MEMORANDUM

Subject: **SAIA – Technical Review 1 – Project Resubmittal Responses**
PA22025
80 Columbia Avenue
Marysville, WA 98270

BULK & DIMENSIONAL STANDARDS	
BASE DENSITY: DWELLING UNIT/ACRE	0
MAXIMUM DENSITY: DWELLING UNIT/ACRE	0
MINIMUM STREET SETBACK (3)	NONE (7)
MINIMUM INTERIOR SETBACK	NONE (4) 50 FEET (5)
BASE HEIGHT (6)	65 FEET
MAXIMUM IMPERVIOUS SURFACE: PERCENTAGE	85%

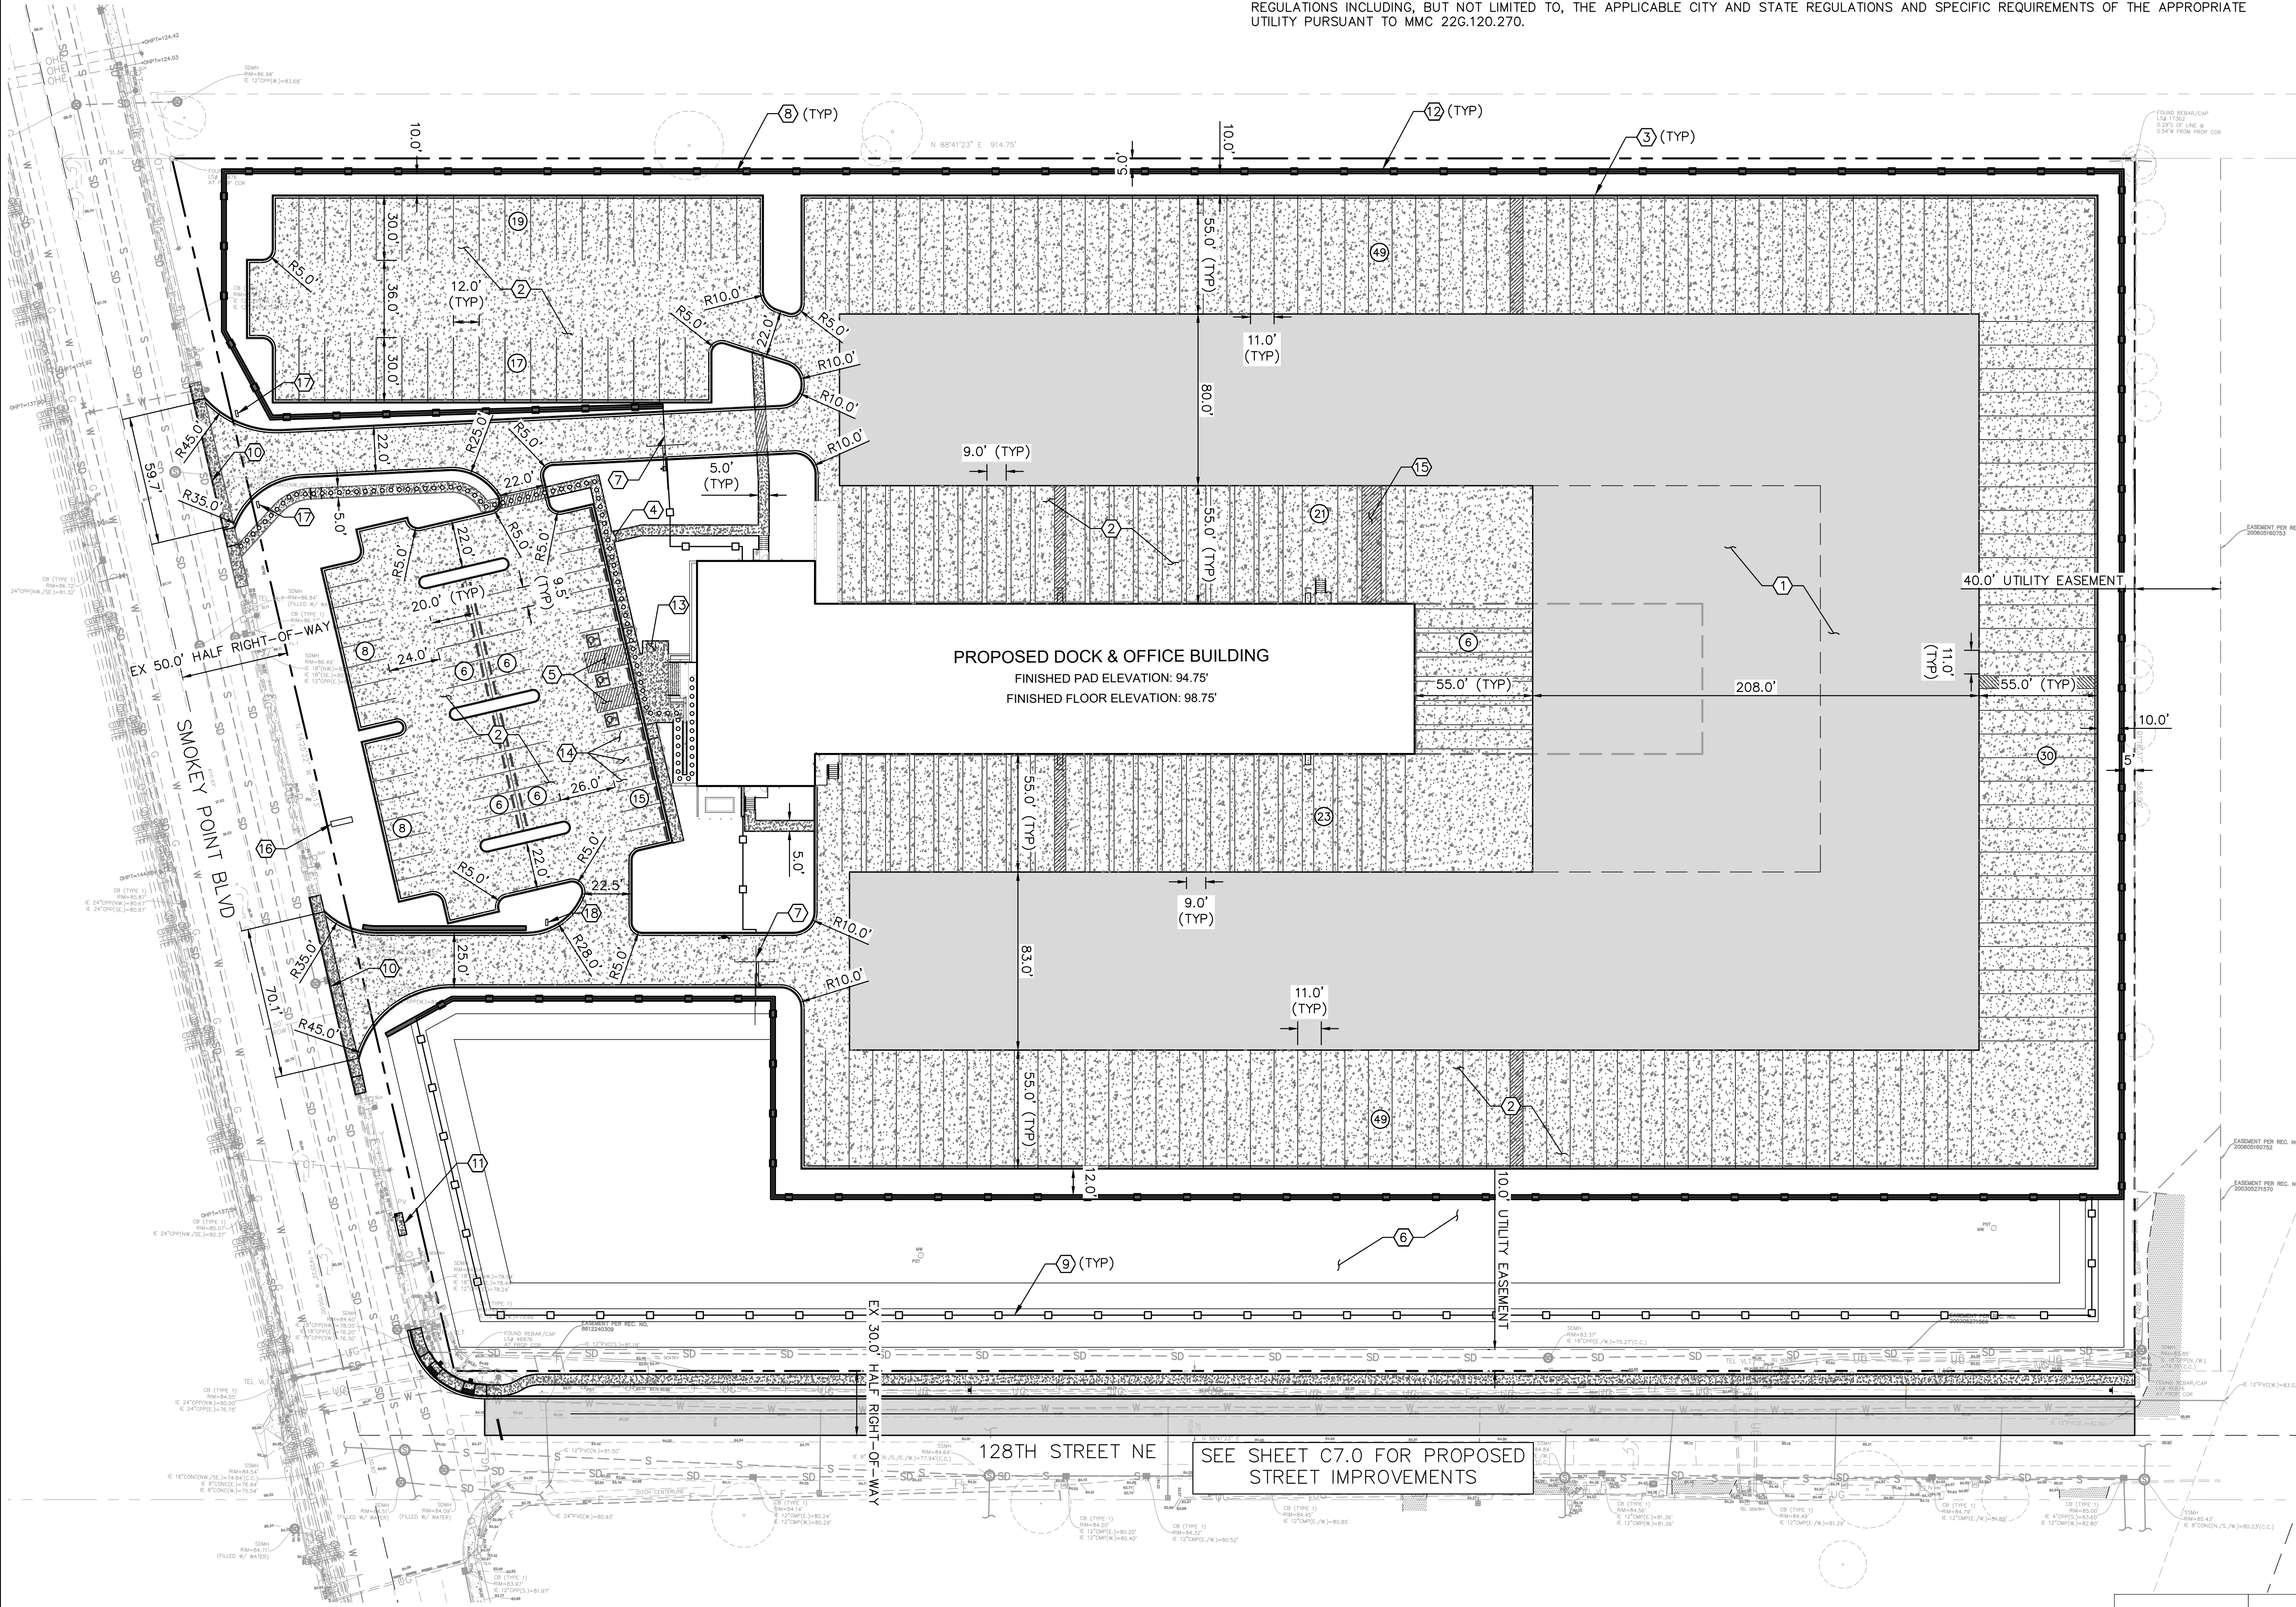
3. The signed Snohomish County Traffic Offer is included with this resubmittal. Payment will be made prior to building permit issuance.
4. The following comments apply to Sheet C4.0:

- a) Bulk & dimensional calculations have been added to Sheet C4.0
 - b) Parking calculations and table have been added to Sheet C4.0
 - c) Carpool parking locations added to plans and calculations added to the parking calculations table on Sheet C4.0.

- d) Required bicycle parking locations added to plans and calculations added to the parking calculations table on Sheet C4.0.
 - e) Drive-aisles at the northern entry way and employee parking lots have been widened to minimum 22-feet.

- f) Pedestrian pathway has been relocated 5-feet south of the drive aisle with street trees added in between.
 - g) Pedestrian pathway decorative concrete will be shown on landscape plans to be included in the civil construction permit submittal.

- h) A solid waste compactor adjacent to the loading dock has been noted on Sheet C4.0. Per email communication with Kristy Beedle at the City of Marysville dated 9/6/2022, no additional enclosure is required if no additional waste or recycling collection is proposed for the site. Per email communication with Chris Holland at the City of Marysville dated 9/8/2022 no additional screening of the compactor is required if the site meets screening standards outline in MMC 22C.120.160.

- i) These details are included as a separate document in this submittal.
 - j) The proposed retaining wall on the north property boundary has been revised to be maximum 4-feet in height. It has also been shifted to allow for 5-feet of landscaping between the base of the wall and the property line.

- k) All listed notes have been provided on Sheet C4.0.
